BUILDING INSPECTION PERMIT

Permit Number: 060290

has permission to install Kitchen exhaust system 2 hoods with up air

AT 425 FOREST AVE

REVISIONS		
NO.	DATE	DESCRIPTION
1	2/27/06	RELOCATED FAN FOR 10' SEPARATION TO PROPERTY LINE
2	3/1/06	ADDED STRUCTURAL COMPONENTS
3	3/20/06	ADDED FAN WEIGHTS

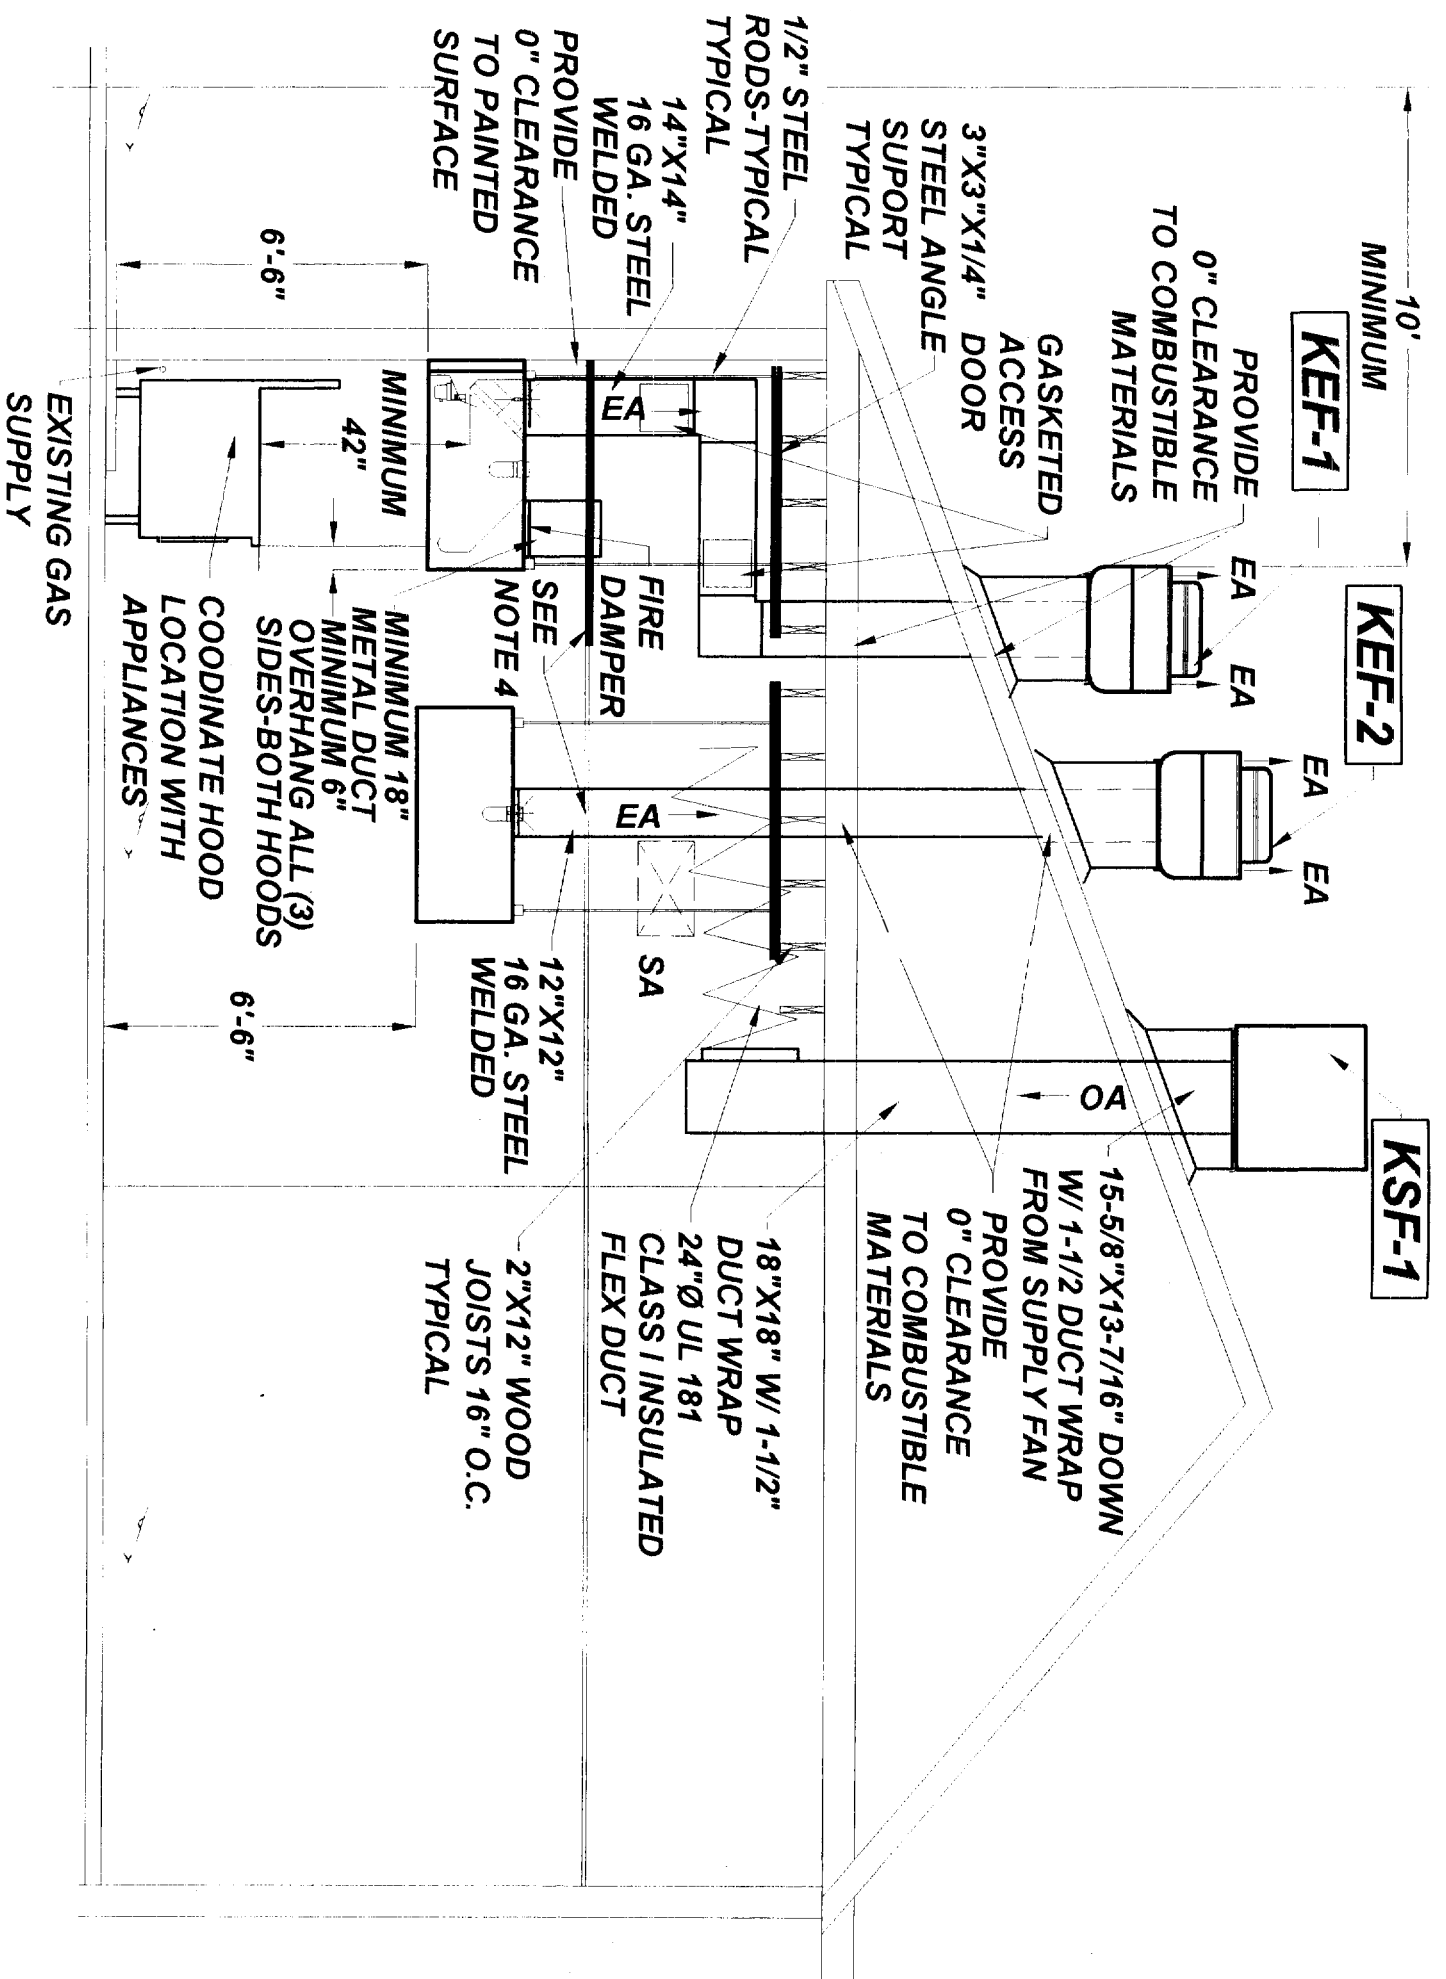
Dept: Fire	Status: Approved with Conditions	Reviewer: Cptn Greg Cass	Approval Date: 03/06/2006
Note:	Ok to Issue:		
1) Install shall comply with NFPA 96
